**Green Square Integrated  
Community Facility & School**  
3 Joynton Avenue  
Zetland NSW 2017

**ACCESSIBILITY  
REPORT**

**Our Ref:** AN020-215729  
**Date:** 23/07/2021

GA PLAN - LEVEL 02

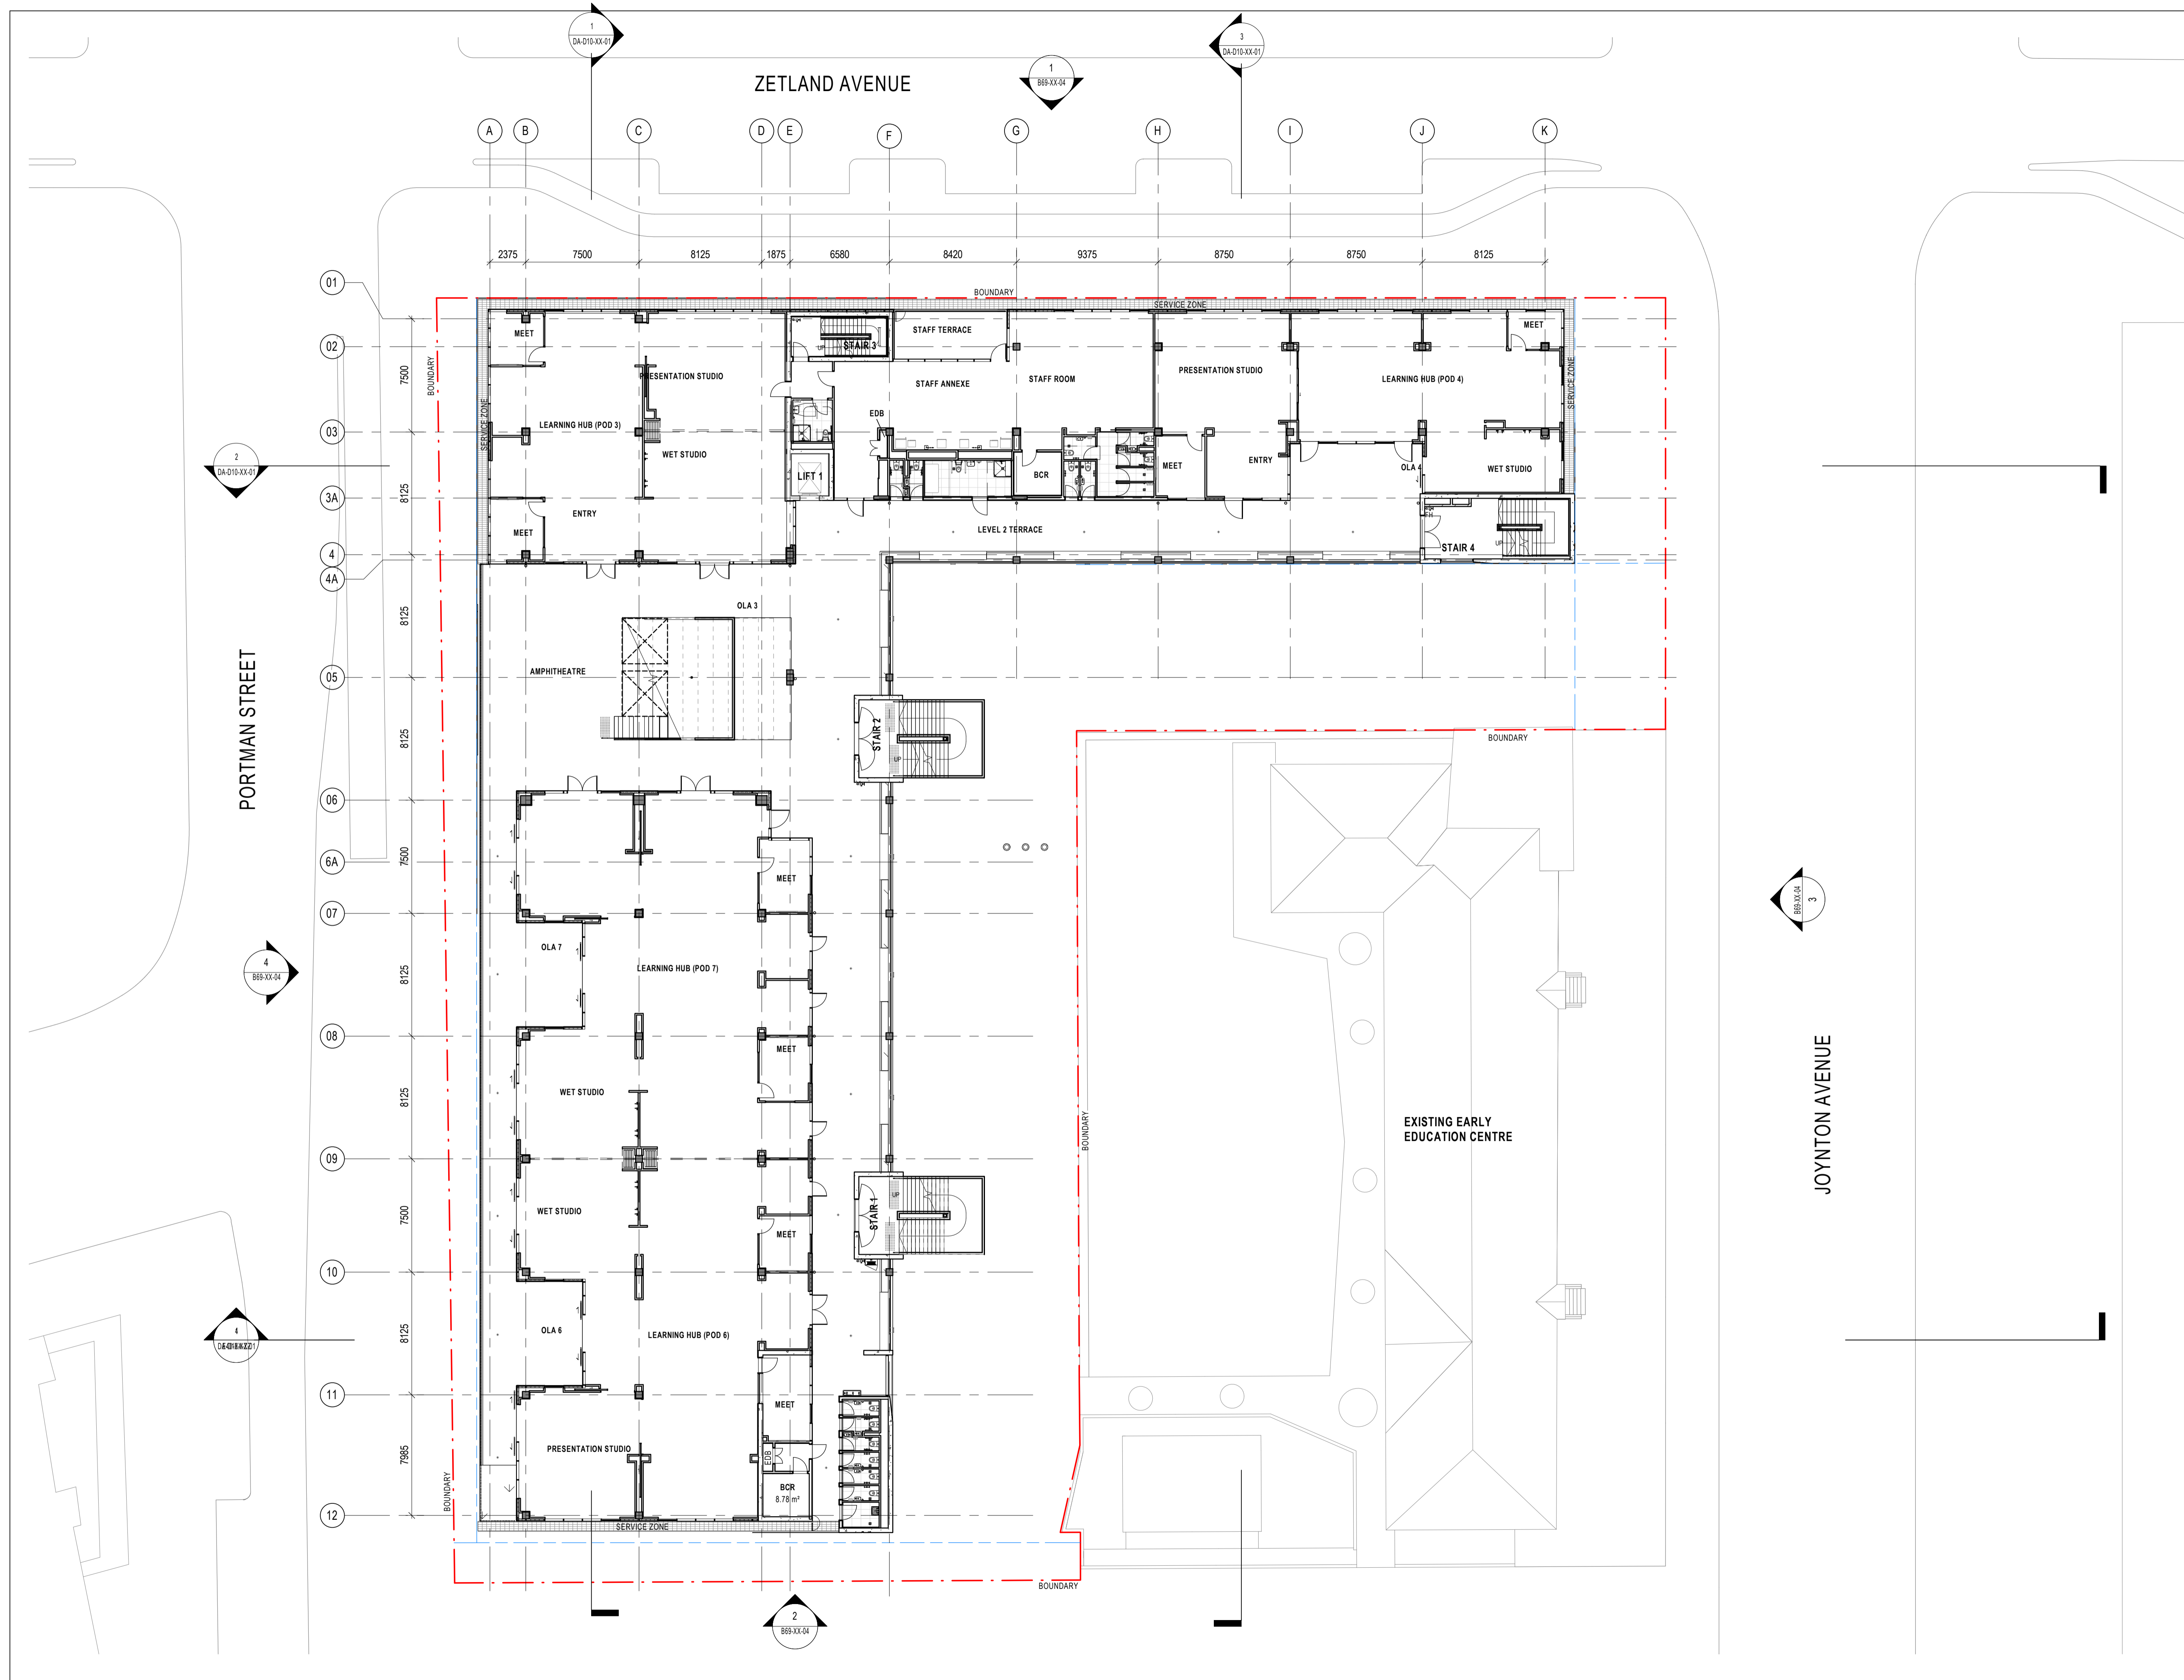
- b) There is a vestibule along a required accessway outside the unisex accessible sanitary compartment on level 02, that can be modified to accommodate minimum 1450mm clearance between the successive door swings for compliance with AS1428.1-2009 and to provide access to and within all areas in accordance with BCA D3.1.

- d) There is an unisex accessible sanitary compartment proposed on level 02 that can be increased in overall all dimensions (e.g. min. 2350mm wide by 2750mm long), to accommodate all the required circulation spaces around a pan, basin and shower for compliance with AS1428.1-2009 as required by BCA F2.4.

GA PLAN - LEVEL 03

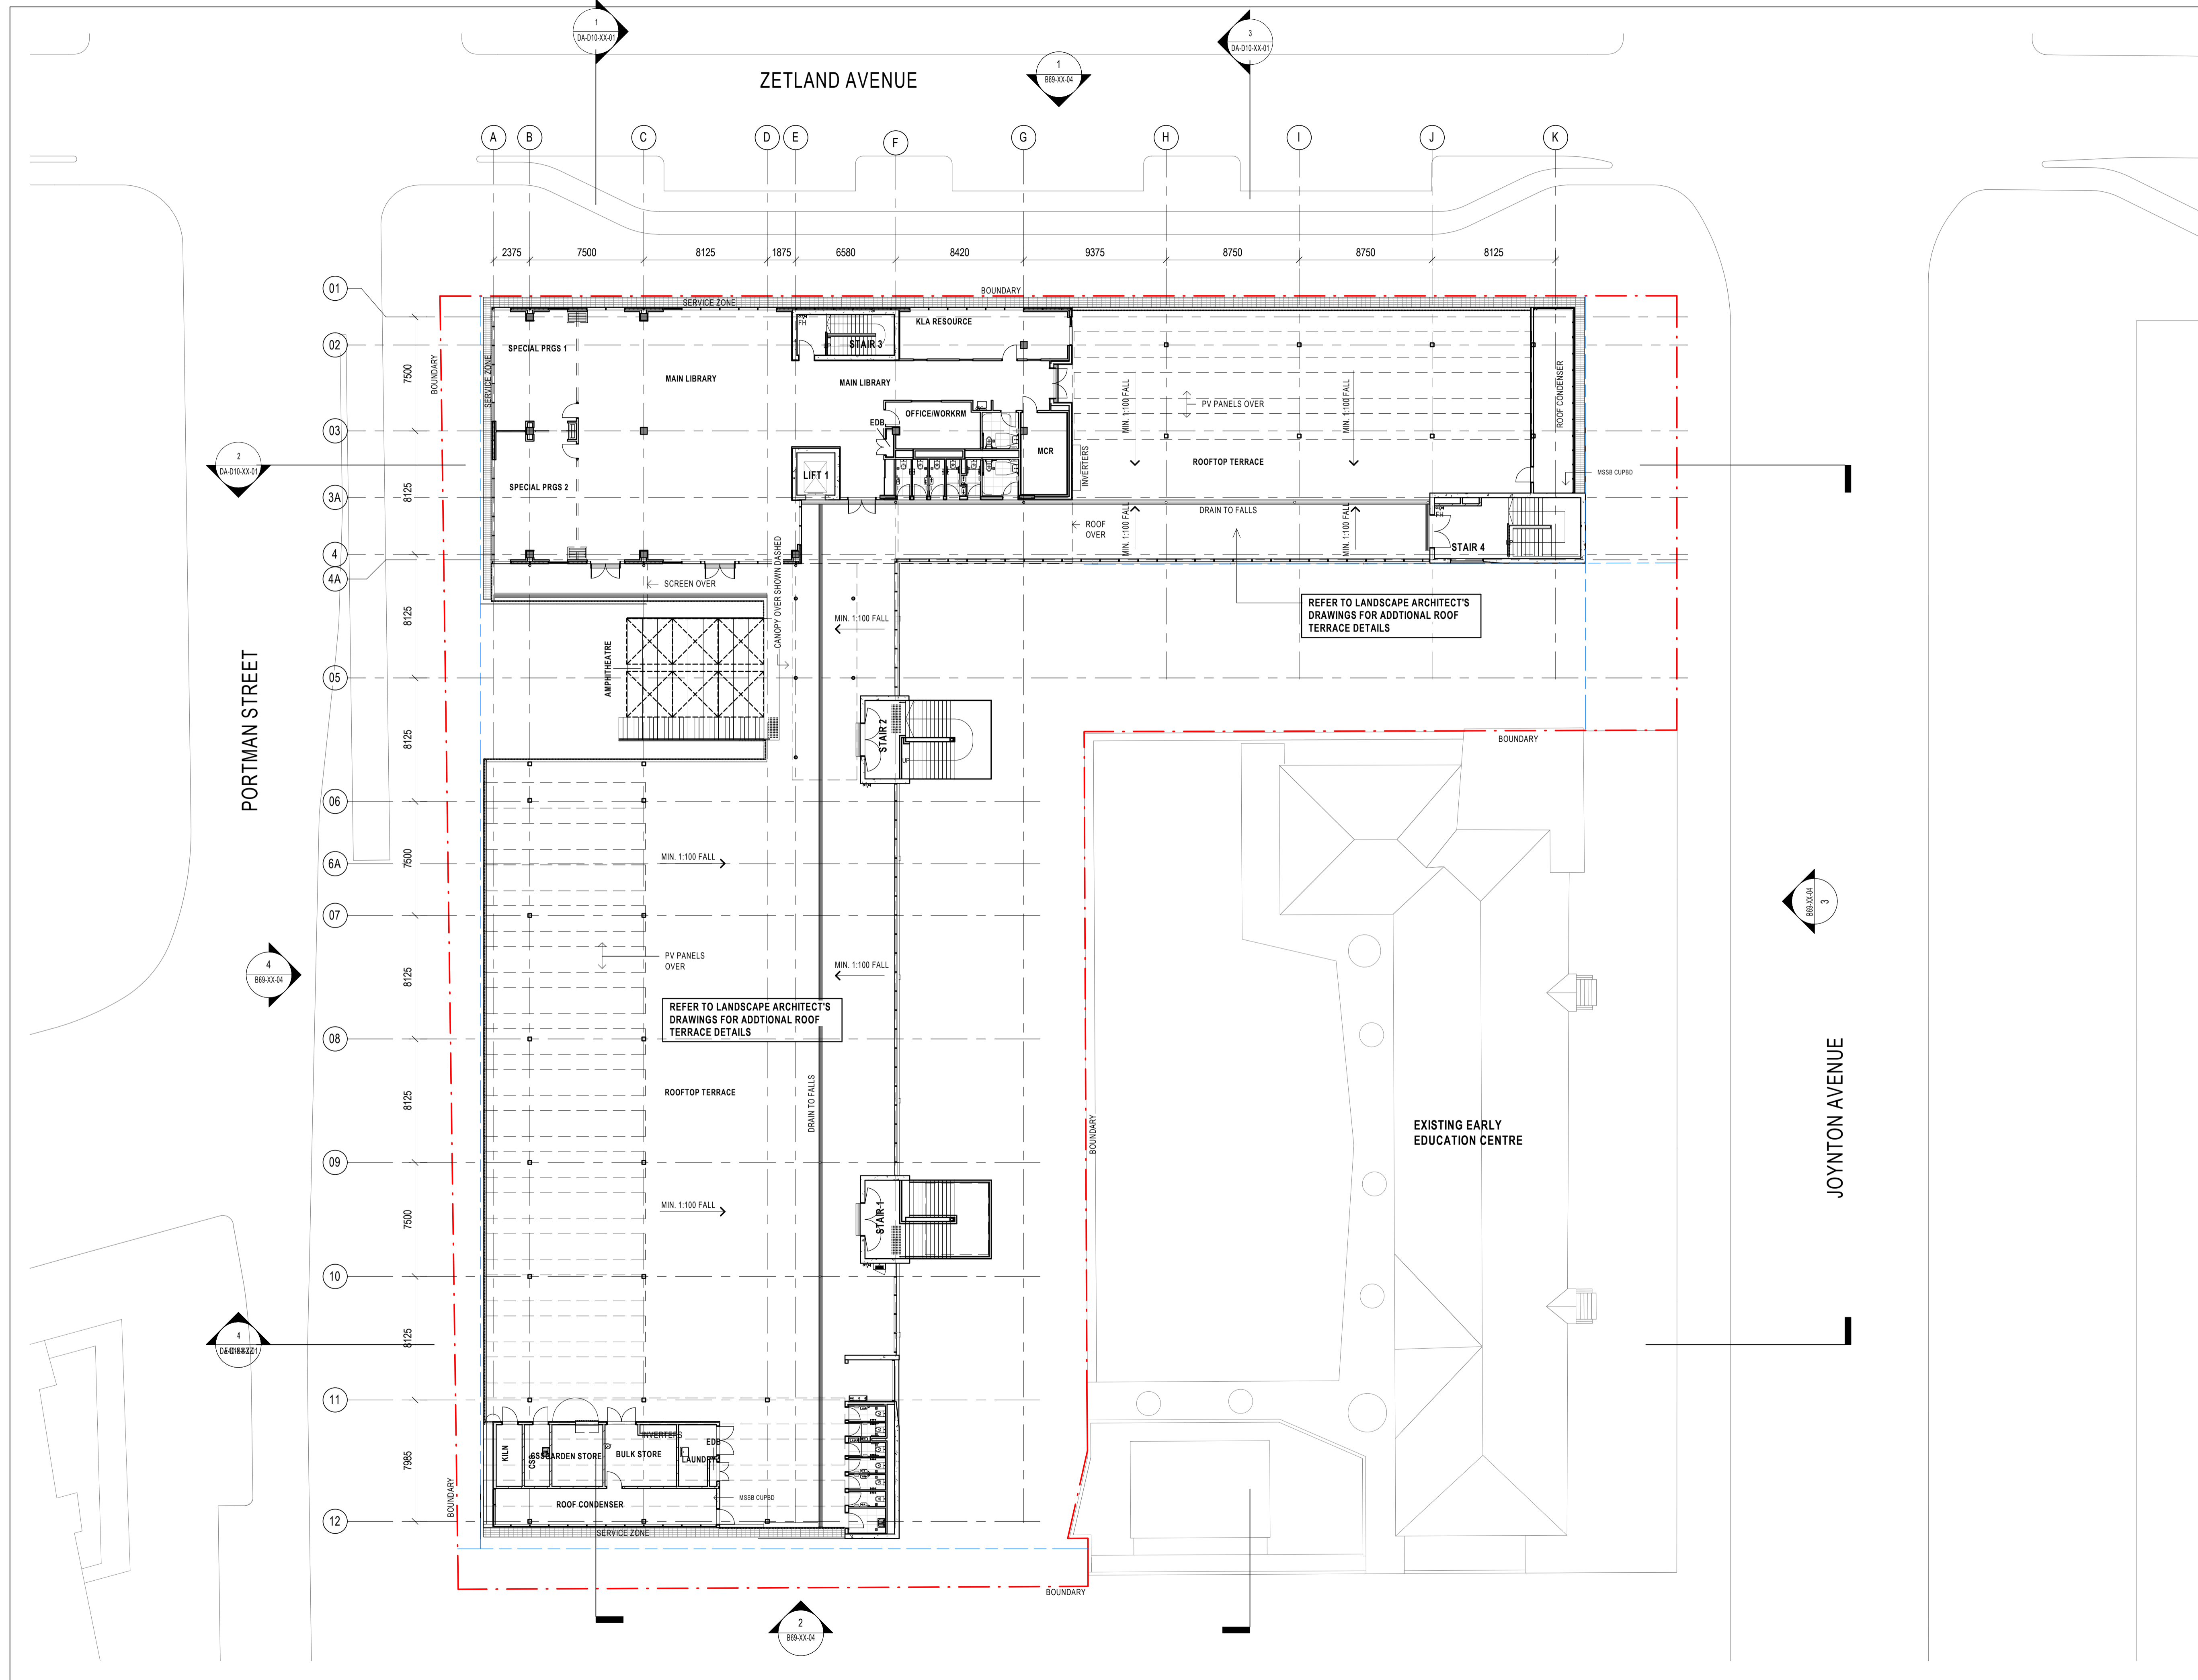
- a) There are multiple doorways along required accessways on ground floor, levels 1 and 3 of the new school building that can be increased in door circulation spaces for manual operation and/or that can be on power operation or automation for compliance with AS1428.1-2009 and to provide access to and within all areas in accordance with BCA D3.1.
